May 6, 2014

**Subject: 421 Warren Avenue  
Final Site Plan Application/Delegated Review Stormwater  
Comment Response #1 Supplemental information**

**BOUNDARY SURVEY**

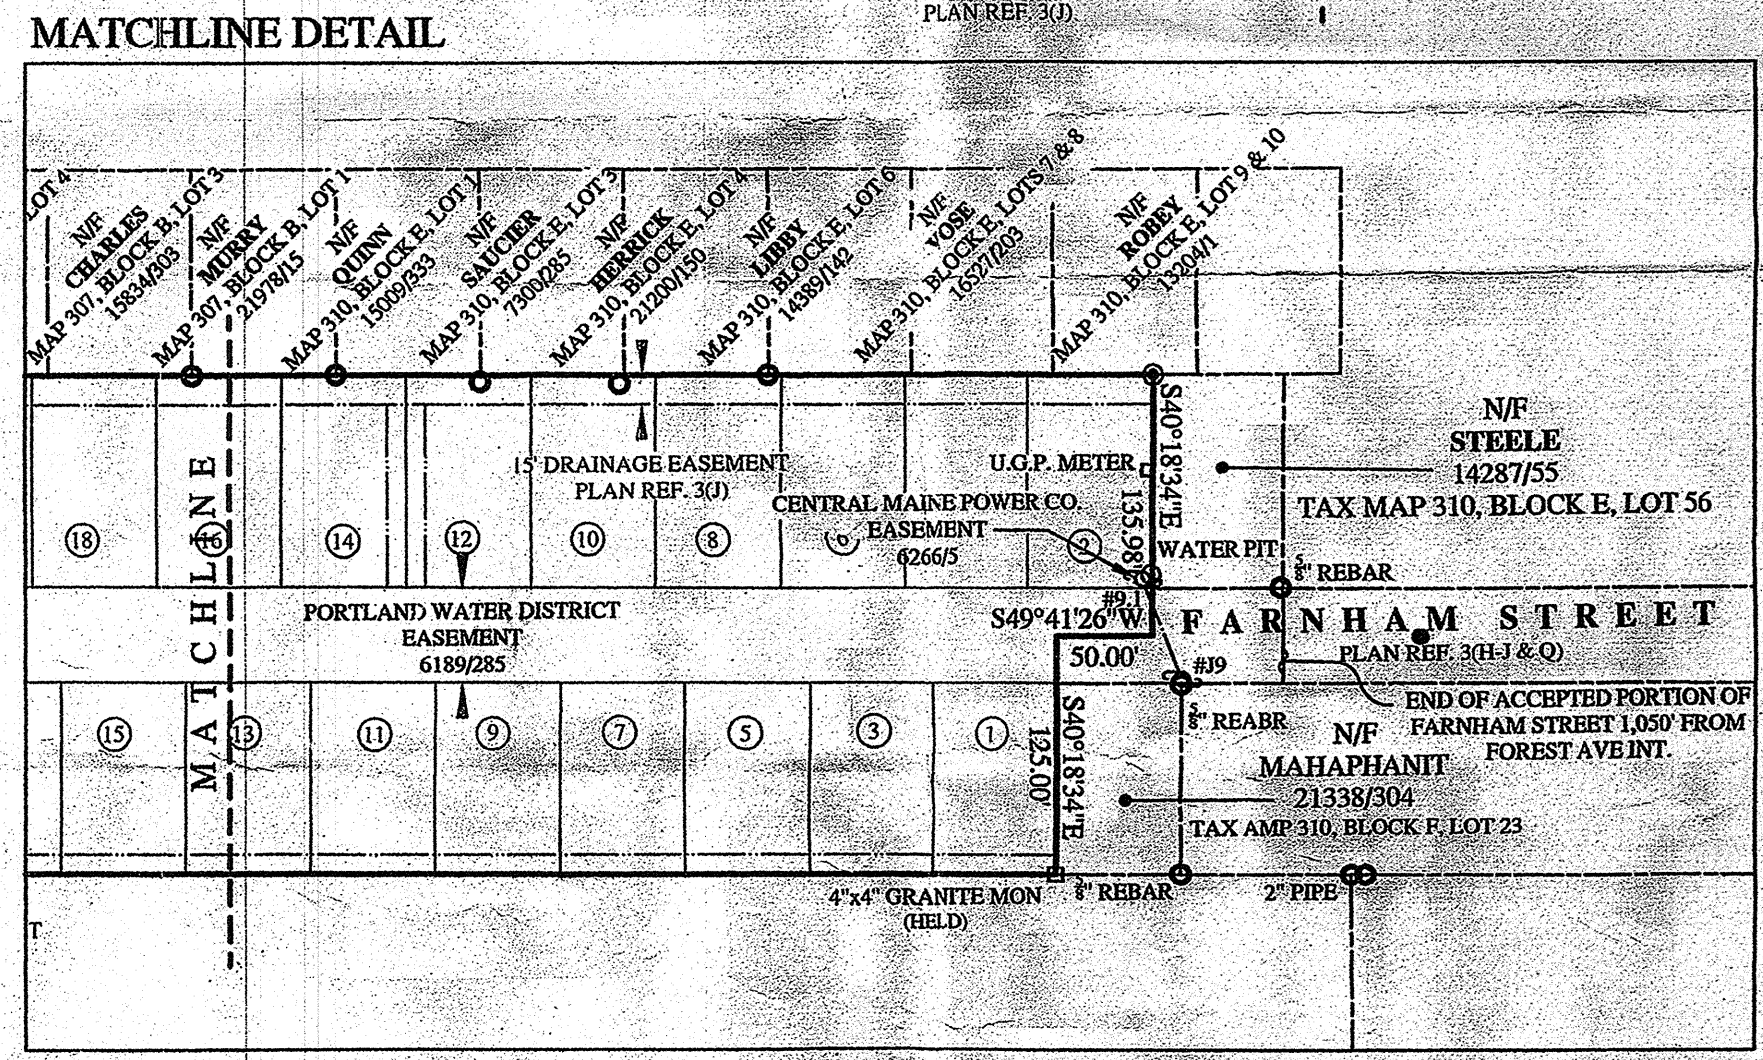
*Comment 3: Please note on survey plan that Saville Street and Newcomb Street are continued paper streets as per City Council Order #84 in September 1997.*

*Comment 4: Please add State Plane Coordinates for four (4) corners; at both ends of the rear 657.94' line and at both ends of the 140.51' line along Warren Avenue.*

Response: The applicant's surveyor has been made aware of this comment. Staff should advise as to the need for an updated plan if necessary.

Response: This information will be provided on an updated plan once received from the surveyor. This will be provided to your attention under separate cover in advance of the Public Hearing.

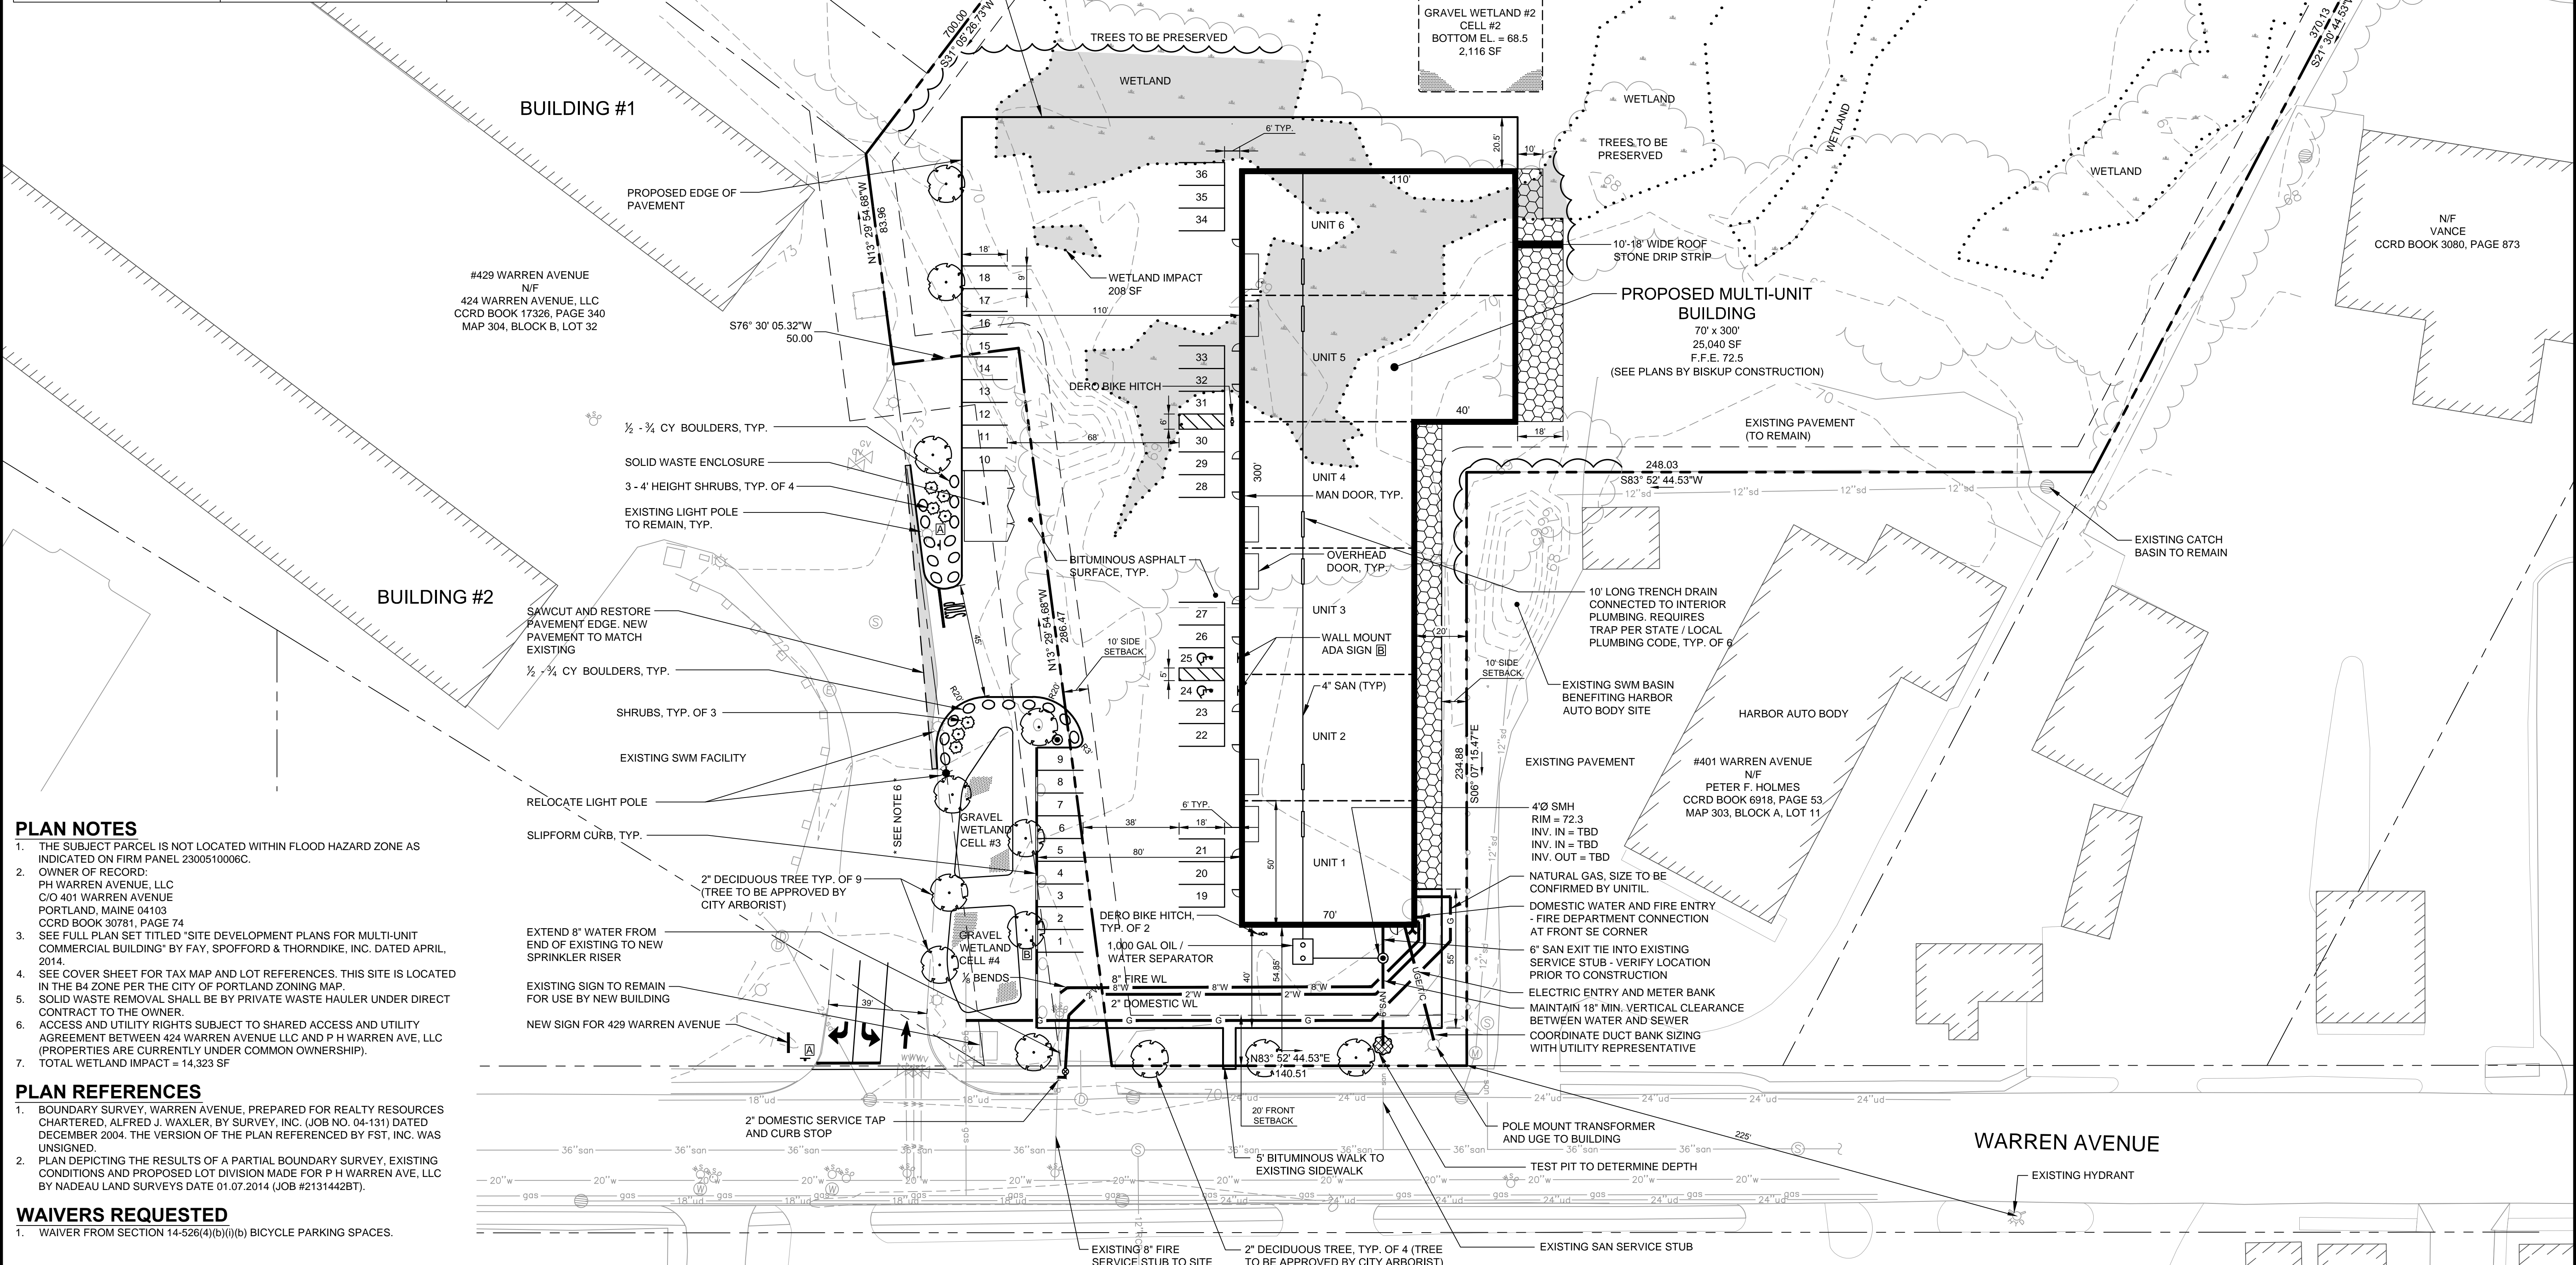
*Comment 1: Since the curb cut on Warren Ave in front of this project is not proposed to be used, the applicant is requested to close the curb cut. The curbing shall be set in concrete to match the abutting curb cut. Please contact Rhonda Zazzara for details 874-8831*

*Comment 2: It would be desirable for the applicant to tap for the 2" domestic water service behind the sidewalk to avoid cutting the sidewalk.*

Response: The applicant will complete the curb cut closure in accordance with the City standards.

Response: It is the applicant's intention to complete the domestic water service tap per this recommendation. The tap will be behind the sidewalk to the extent practicable, but within the ROW limits per the PWD requirements.
